Recommendation Report for Planning Permission for Works or Extension to a Dwelling

REF NO: BE/120/14/HH

LOCATION: 13 Newtown Avenue
Bognor Regis

PROPOSAL: Two storey side & single storey rear extensions (resubmission following BE/68/14/HH).

Proposed Front Elevation (South)

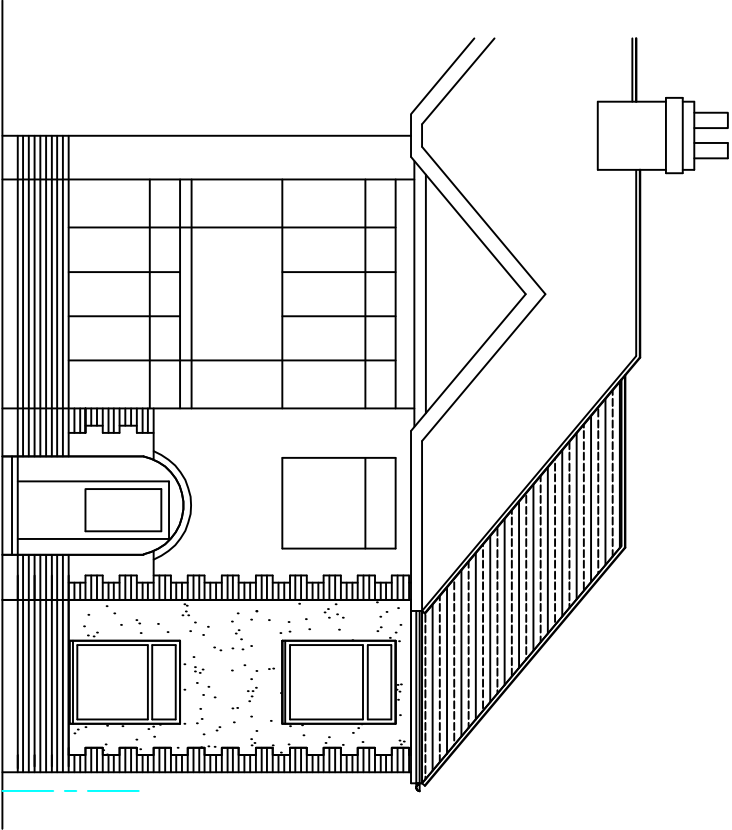
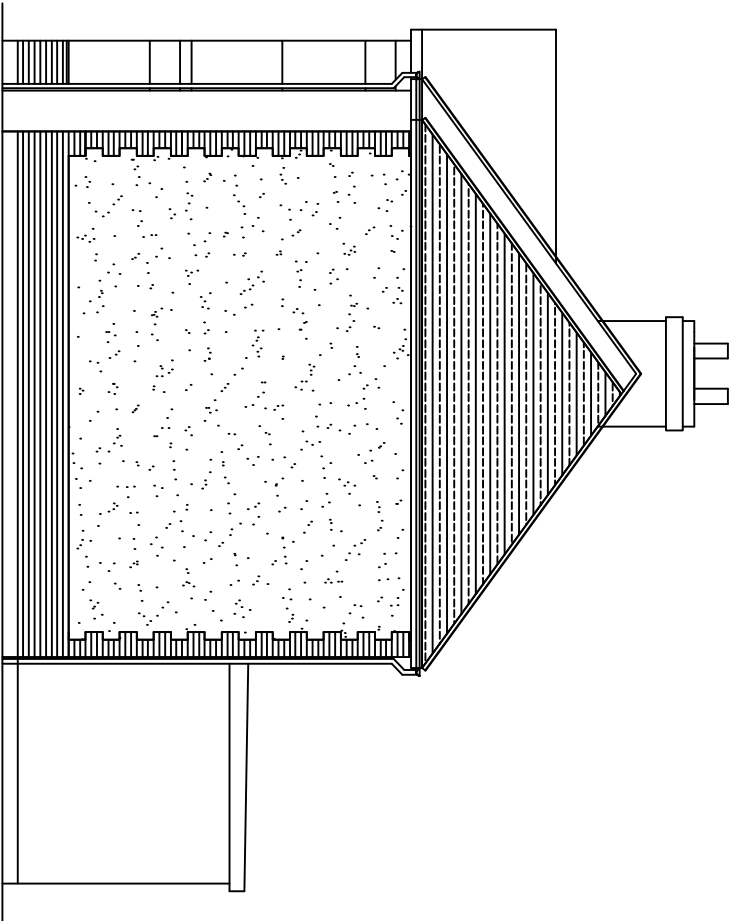
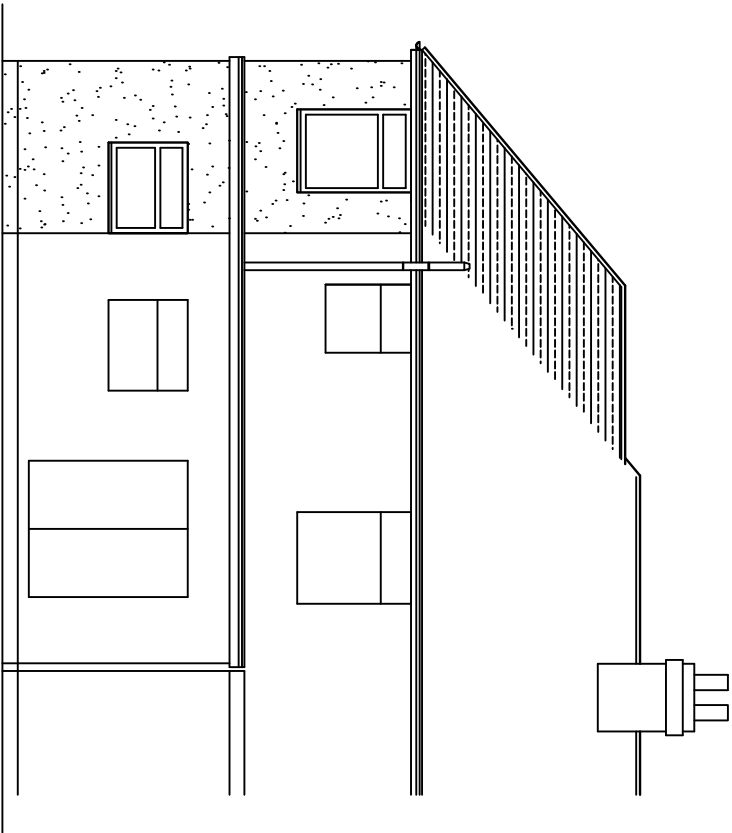
It is noted that the siting, reduced length and roof height has been reduced. However, within the street scene there is the absence of two storey elements and this retains an open and spacious appearance at first floor level which contributes to a feeling of space which is in conflict with Policy DEV19(v).

- 1 The proposed two storey extension adjacent to the eastern side boundary of the site with No 11 would by reason of its scale, height and massing result in an erosion of space which would be out of character and appearance within the street scene in conflict with policies DEV19(v), GEN7 of the Arun District Local Plan, policies DDM1 & DDM4 of the Emerging Local Plan and policy ES1 of the Bersted Neighbourhood Plan.

Proposed Ground Floor Plan

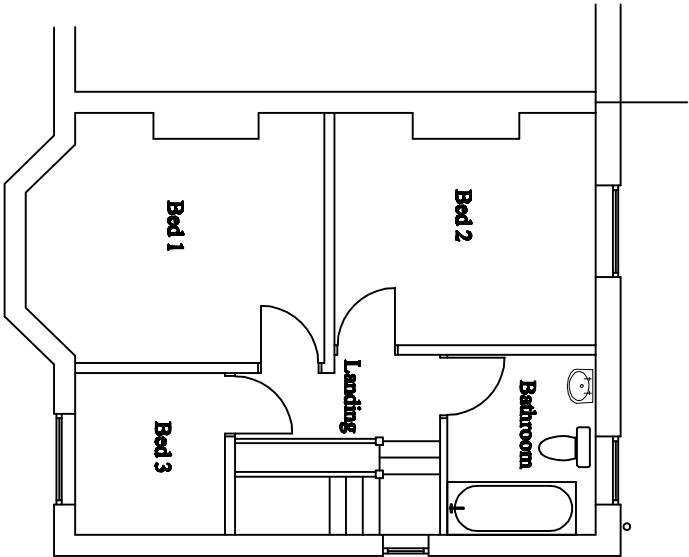
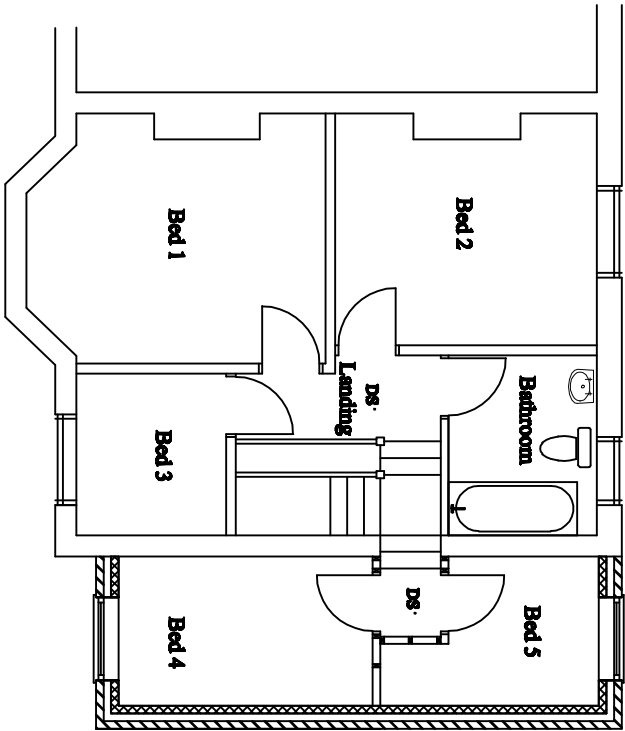
The property has an attached garage on the eastern side and a rear single storey flat roof extension which is the whole width of the dwelling. The proposal seeks to remove the attached garage and rear flat roof wc extension and construct a two storey side extension. The amended plans have reduced the length of the extension and its siting which is now approximately 0.2m away from the neighbouring boundary. The two storey extension is set back from the front flank wall of the dwelling by 0.5m with the roof height being slightly lower than the main ridge height. The flat roof single storey addition on the rear which has a rear projection of 3m will be sited behind the two storey element and will link up with the existing flat roof extension being the same height. The extension has been designed to respect the style of the existing dwelling.

It is not considered that the loss of the garage would increase the need for parking as there is adequate space to the front of the extension to provide parking within the site.
